**New High School in Wee Waa (SSD-21854025)
Request for additional information**

I refer to the State significant development (SSD) application for a New High School in Wee Waa (SSD-21854025) and the Department's correspondence dated 10 December 2021.

Attachment A – Key issues

01 CULTURAL LANDSCAPE PLAN  
LP03 Scale: 1:200

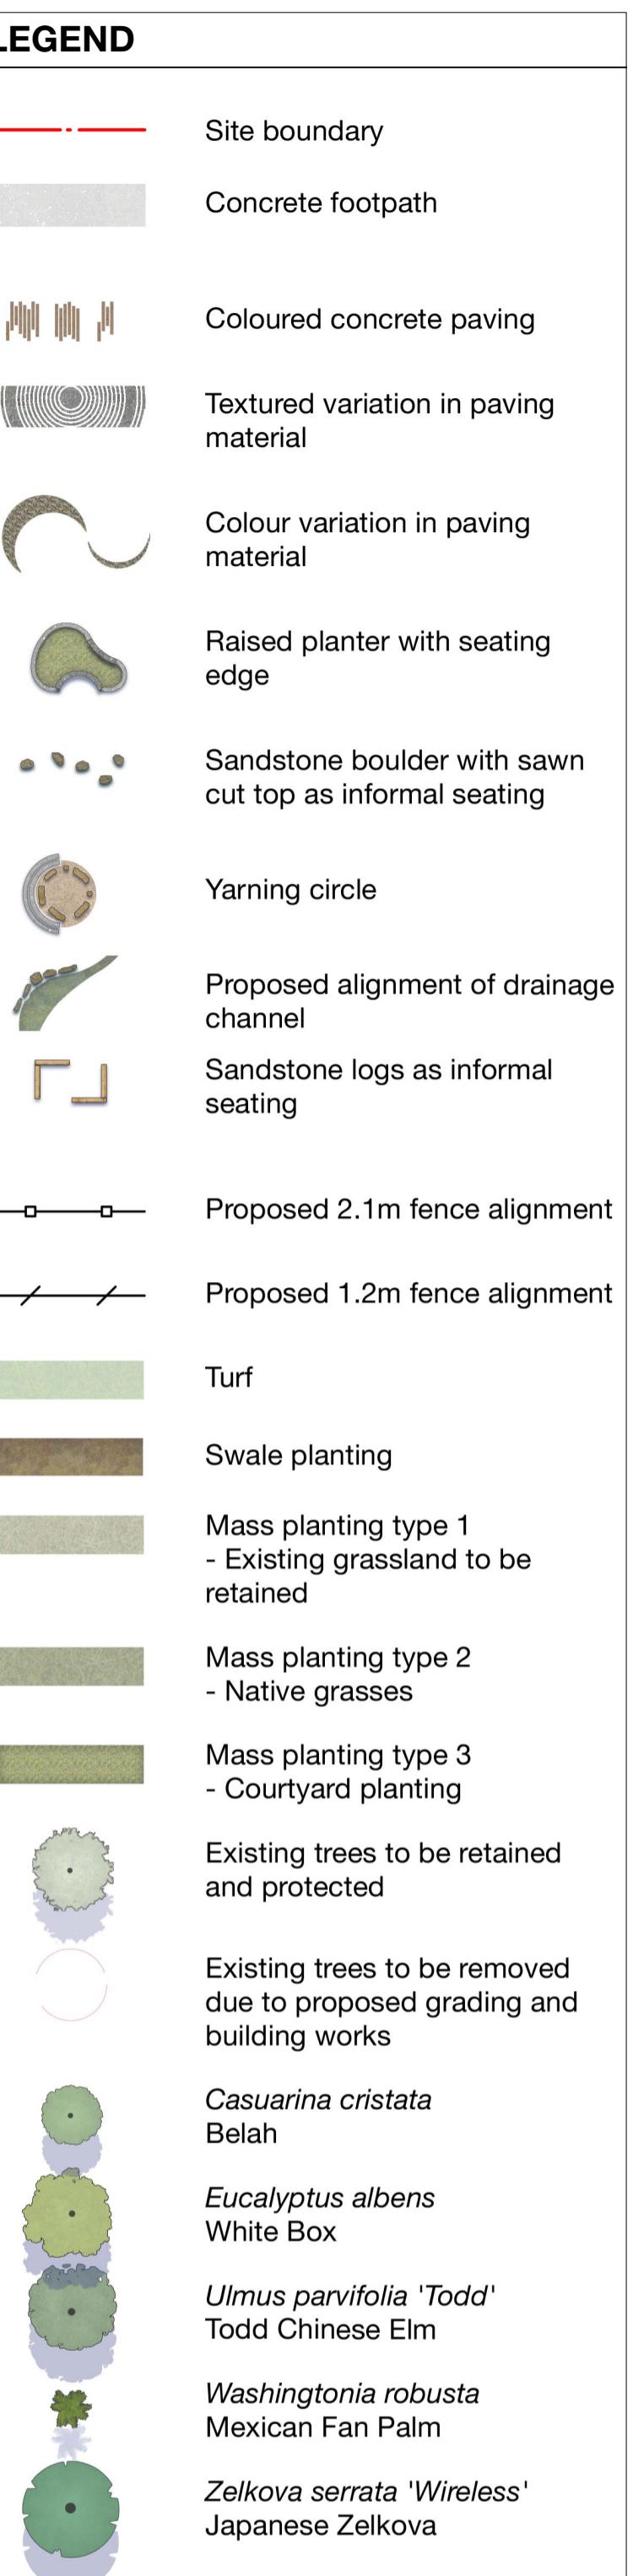
- Justify the inclusion of a high proportion of non-native tree species. In particular, consider replacing exotic species Japanese Zelkova and Chinese Elm with native alternatives that would contribute to biodiversity.
